Ribble Valley
Borough Council

TREE WORK ASSESSMENT

CONSERVATION AREA: WISWELL

APPLICATION NO: 3/2026/0059

Drawing: LTC187-TSP

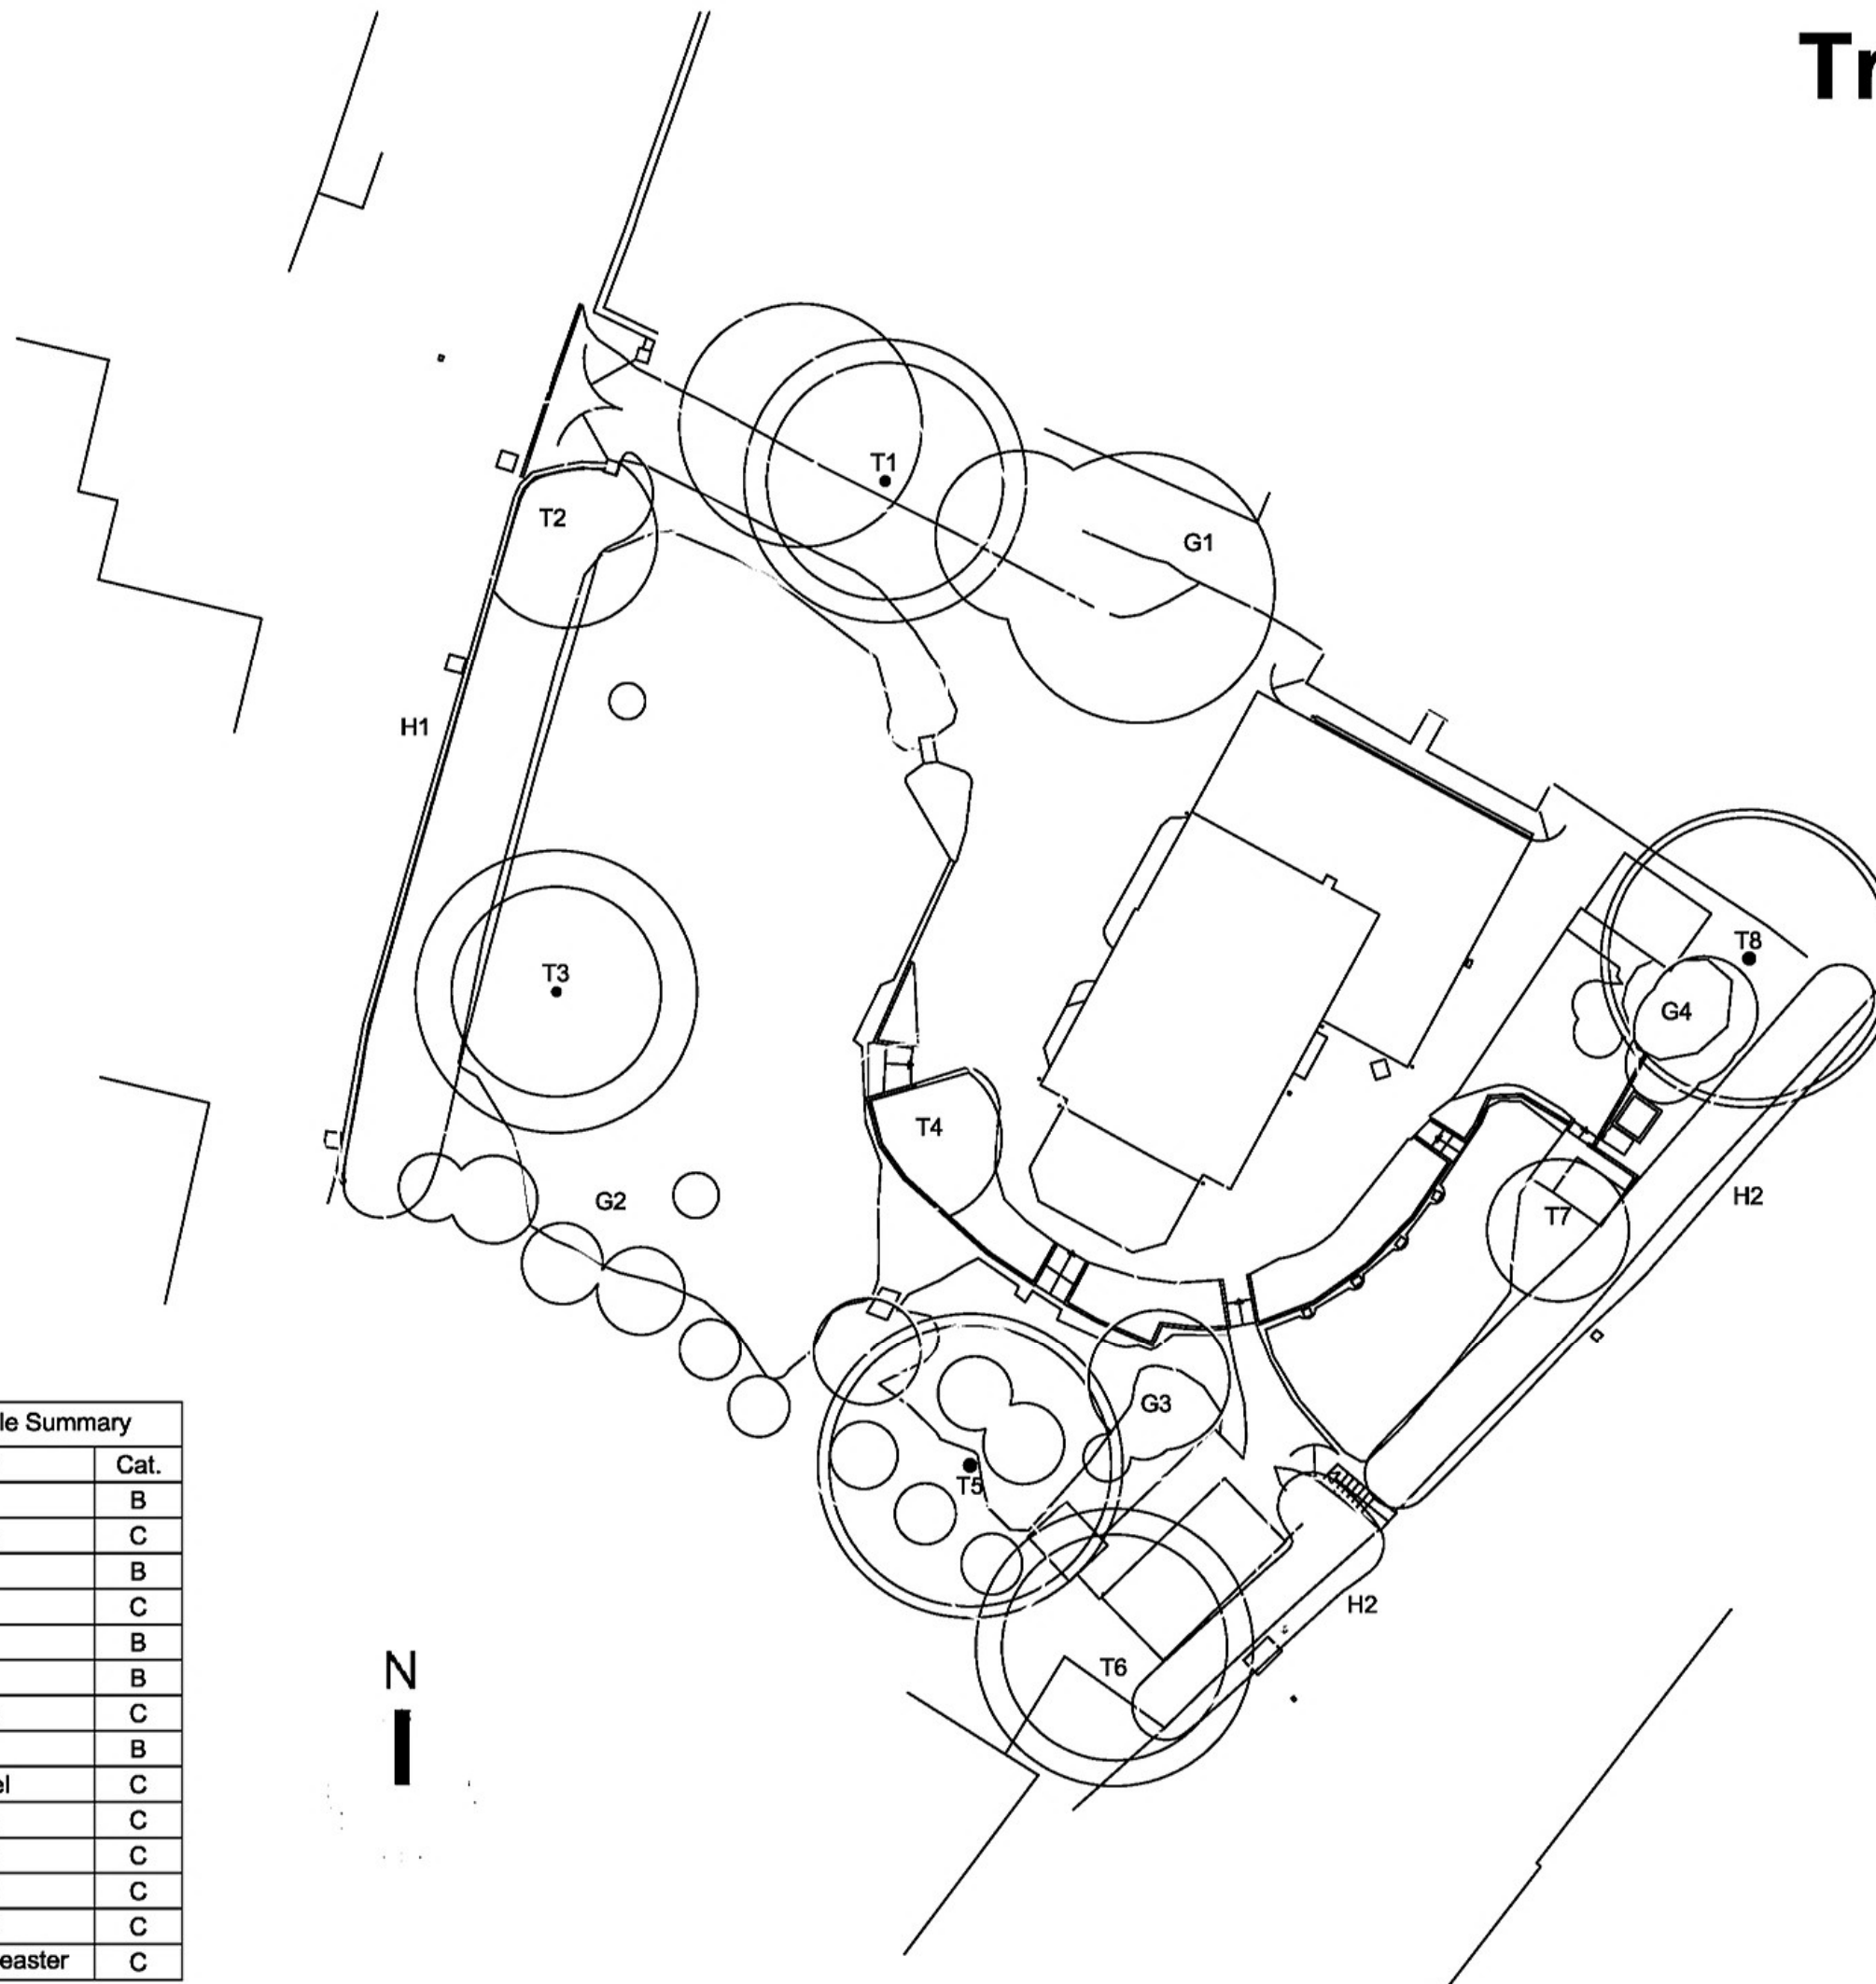
Felling of two trees that have been previously topped out to the extent that visual amenity value of both has become diminished. There will be no significant impact on the wider tree-scape in both the local and wider context however in order to enhance this the owner of the property is planning to carry out replacement planting.

To improve the quality and visual amenity value of the tree cover.
